About the application

Application number: 2026/92464	
What is the application for?:	Listed Building Consent for alterations comprising reconfiguration of internal l
Address of the site or building:	2, Exchange, Honley, Holmfirth, HD9 6AY
Postcode:	HD9 6AY

User comments

Proposed Floor Plans and Elevations

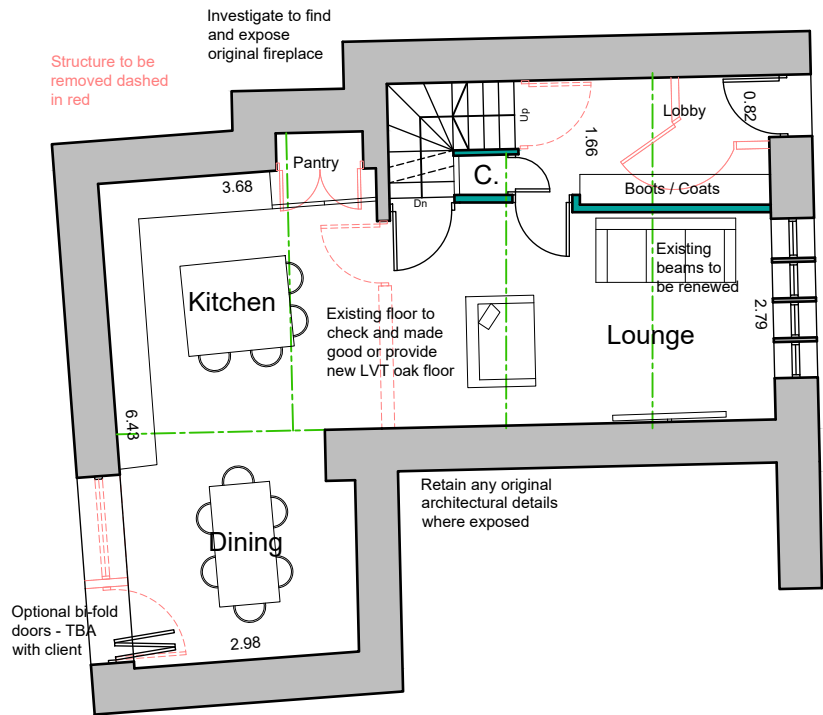
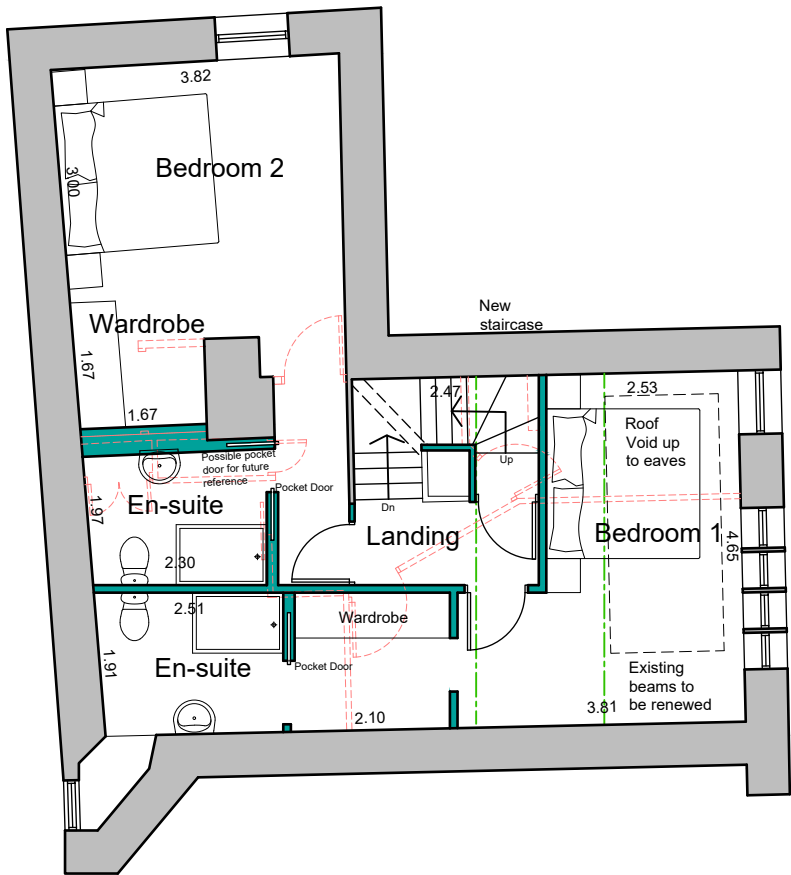
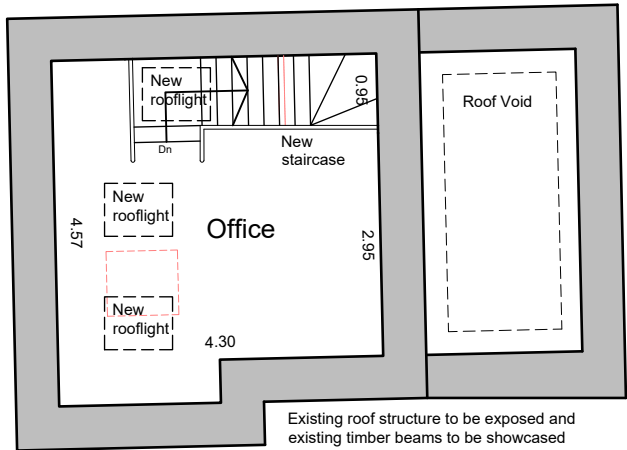
Type of comment: An objection	
Do you wish your comments to be published on the website anonymously?	Yes
<p>I object to the visual changes being proposed on this Listed building I.e demolition of rear house wall, window and stone surround mullions etc disruption to move the gas inlet pipe work, complete visual transformation goes against grade 2 listed buildings ethics.</p> <p>Impacting on neighbours right to privacy and peacefulness.</p>
